**SECTION 96(1A) MODIFICATION APPLICATION SSD - 6724
60-78 REGENT STREET, REDFERN**

On behalf of Iglu Pty Ltd, we hereby submit an application pursuant to section 96(1A) of the *Environmental Planning and Assessment Act, 1979* (EP&A Act) to modify State Significant Development Consent SSD 6724 relating to the construction of an 18 storey student accommodation building with retail and community space at ground floor at 60-78 Regent Street, Redfern.

2.0 PROPOSED MODIFICATIONS TO CONSENT

60-78 Regent St
Redfern
Section CC

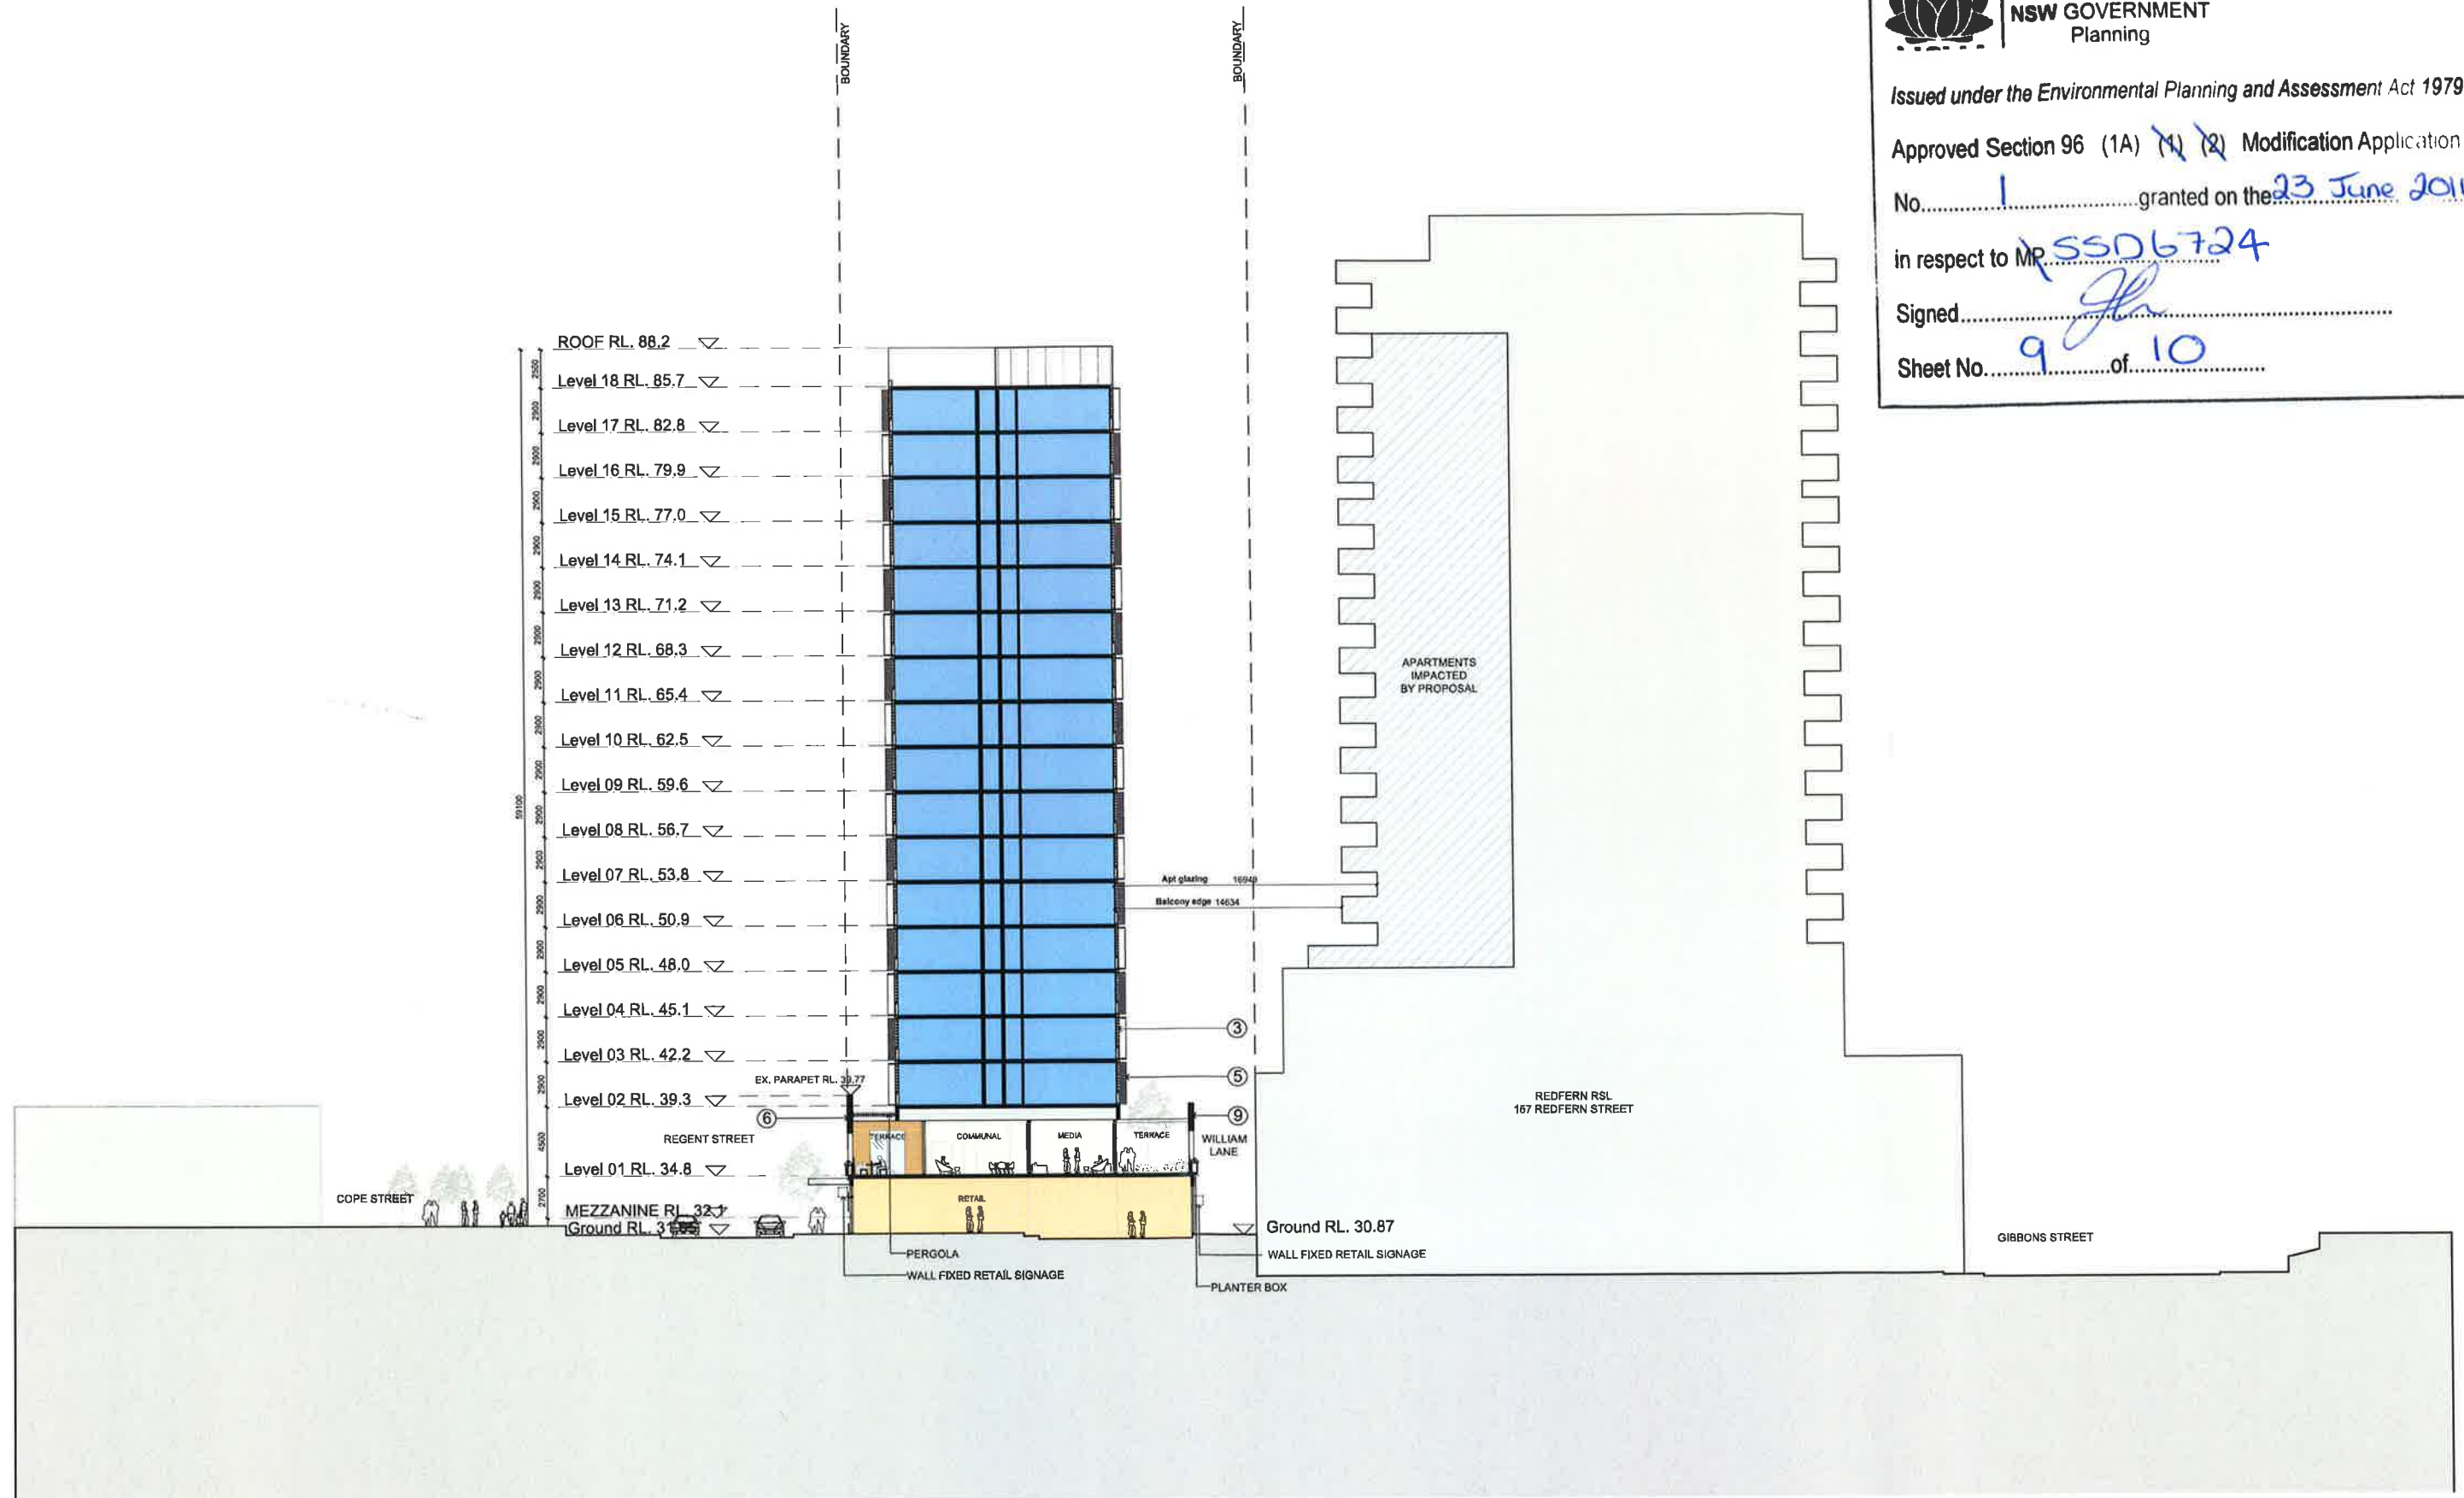
~~Prior to the issue of a construction certificate, plans must be submitted to the certifying authority demonstrating an overall reduction in the building height by 3.2 metres (maximum RL 88.2m AHD). This overall reduction in building height shall be achieved via a reduction in the floor to floor heights to 2.9 metres without affecting the minimum floor to ceiling height of 2.7 metres on Levels 2 to 17.~~

Amended plans reflecting the requirements of this condition are provided with this modification application.
